As a resident on Jason Terrace of 35 years I am not opposed to the development at Clough House. I am aware of the need for additional housing but the destruction of a historic building that has been stood since the 1800s seems unnecessary. Surely the buildings can be incorporated into the development.

My main objection is the access via Moat Hill Farm Drive.

5.0 Movement

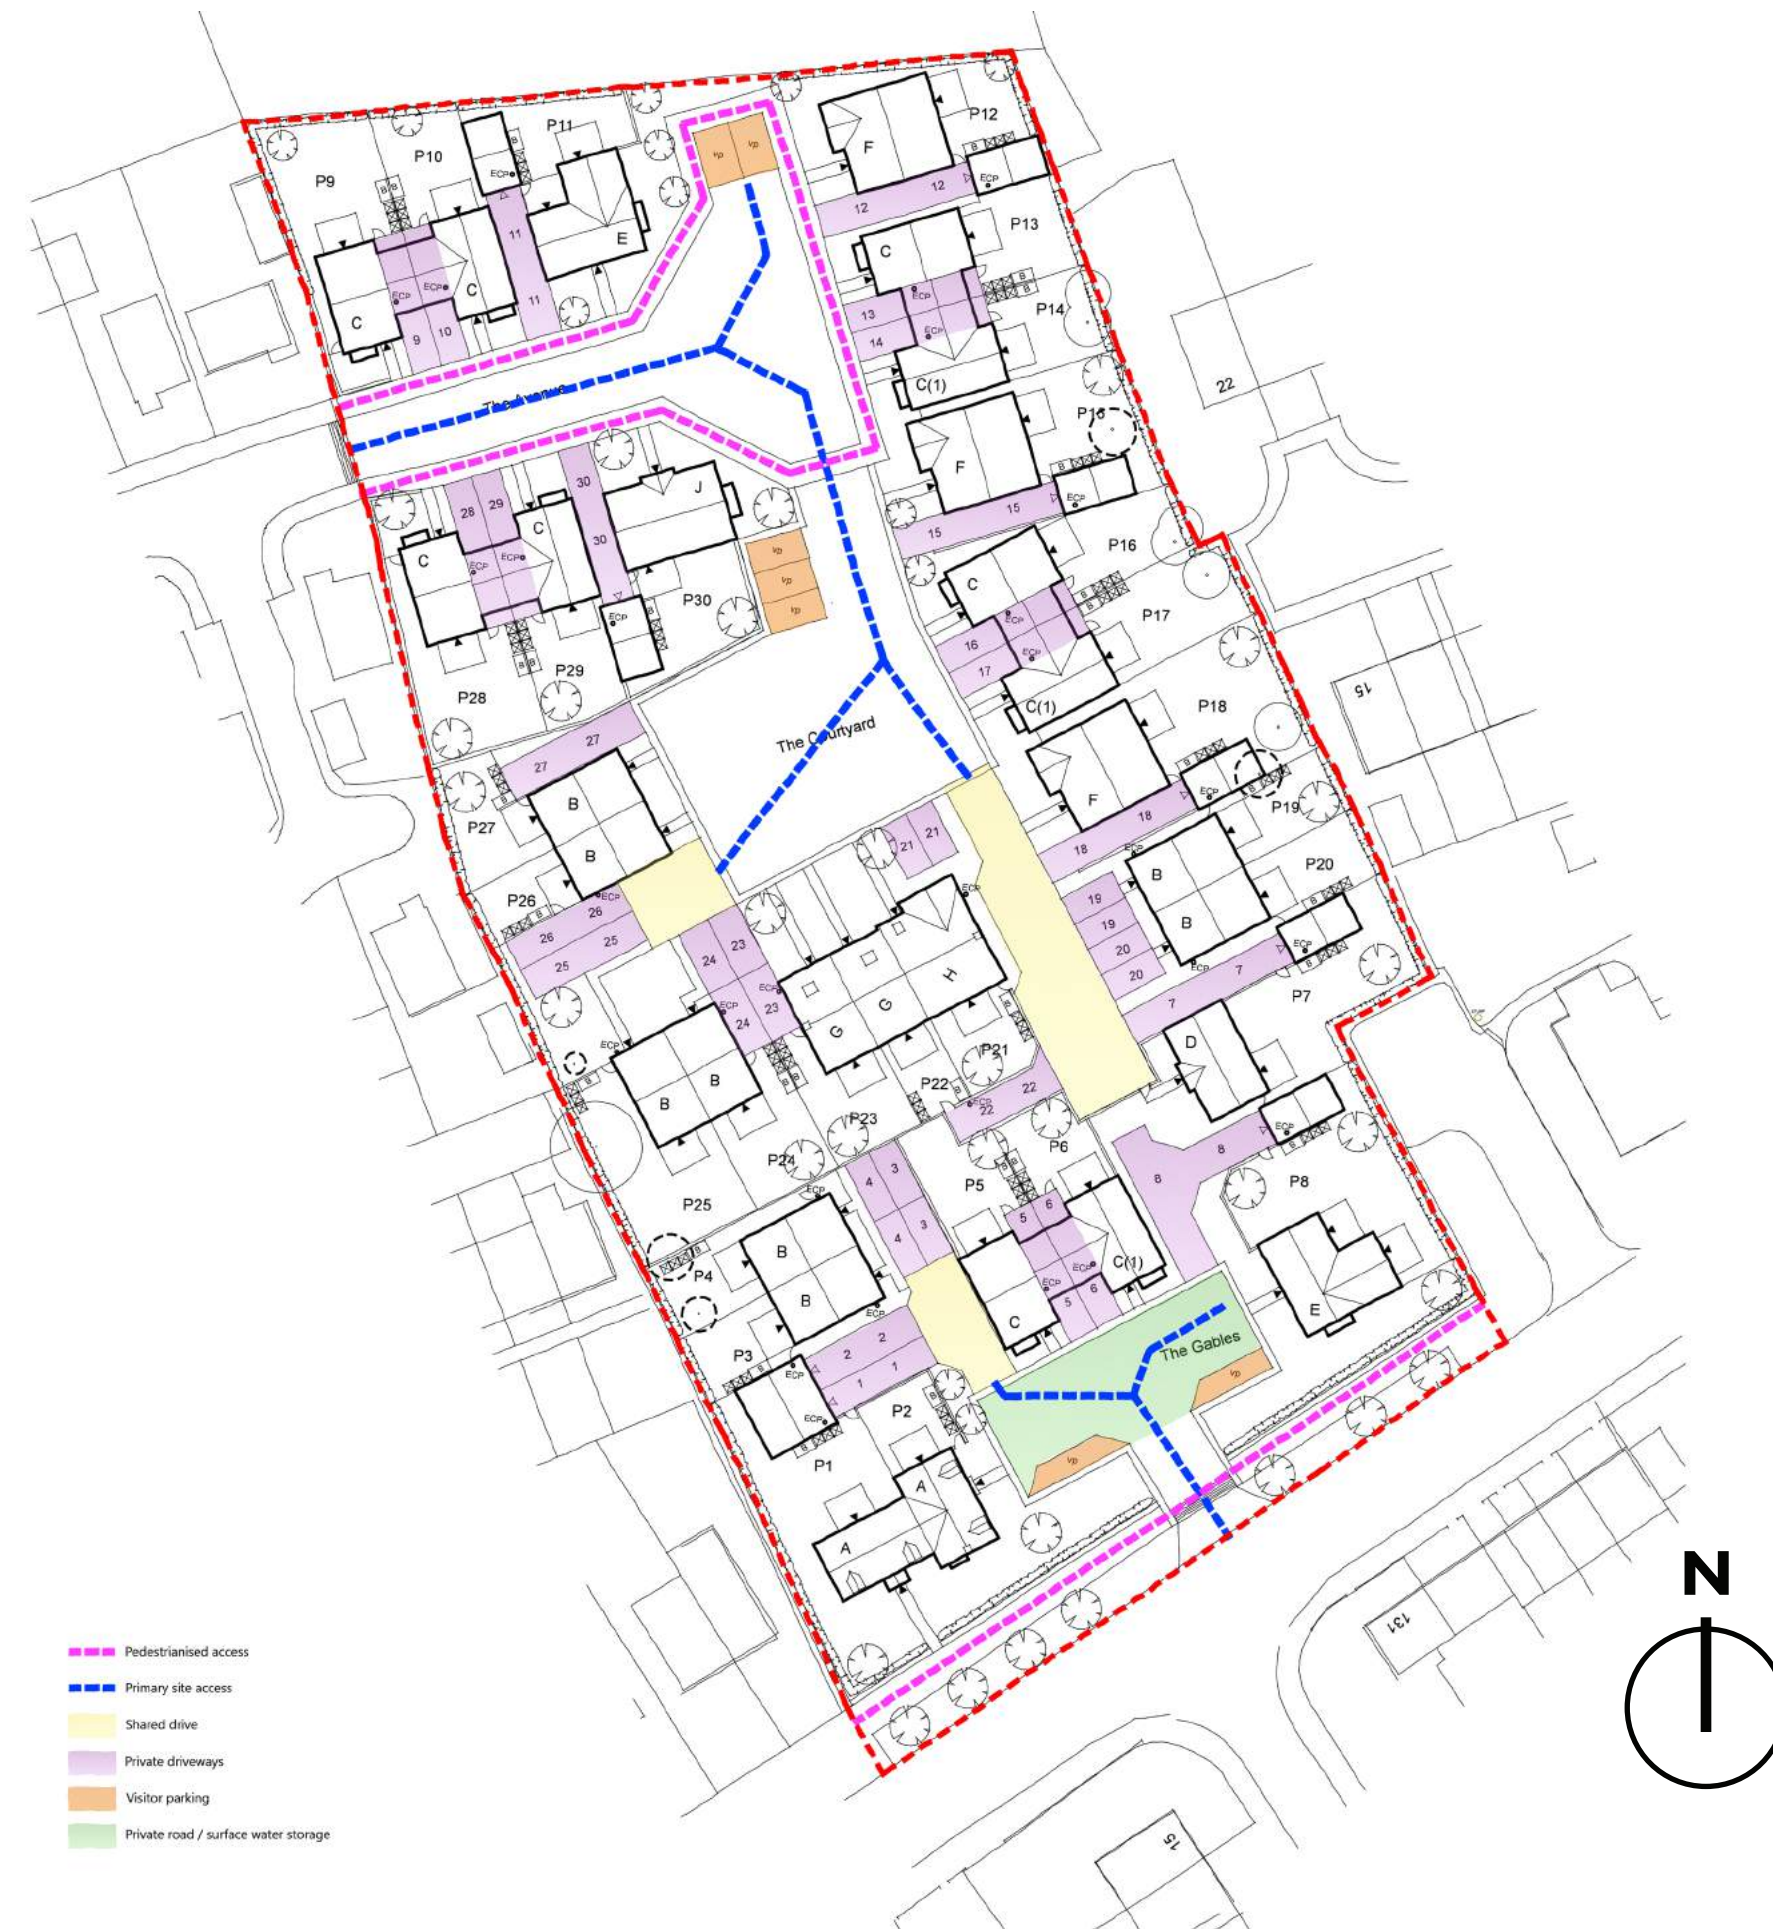
This road already serves 49 houses, 10 of which have been recently built and are not yet fully occupied. Consequently the traffic report submitted is inaccurate. The proposed development has 75 allocated parking spaces, this is not including extra traffic created from visitors and deliveries. This doubles the amount of vehicles on this already busy and congested road, creating a safety hazard for other motorists and residents.

The junction of Moat Hill Farm Drive and Leeds Road is on a crossroads with a very busy road, Hill Crescent and the brow of a hill. Visibility is not good due to cars parked on Leeds Road. A potential extra 75 vehicles using this junction will increase the risk of serious road traffic collisions.

The proper infrastructure should be put in to allow all access direct from Leeds Road. Visibility is clearer in both directions, on the level and opposite a much quieter road, Dudley Avenue. Also there is a speed camera at this location. The plans could easily be altered to allow full access from Leeds Road.
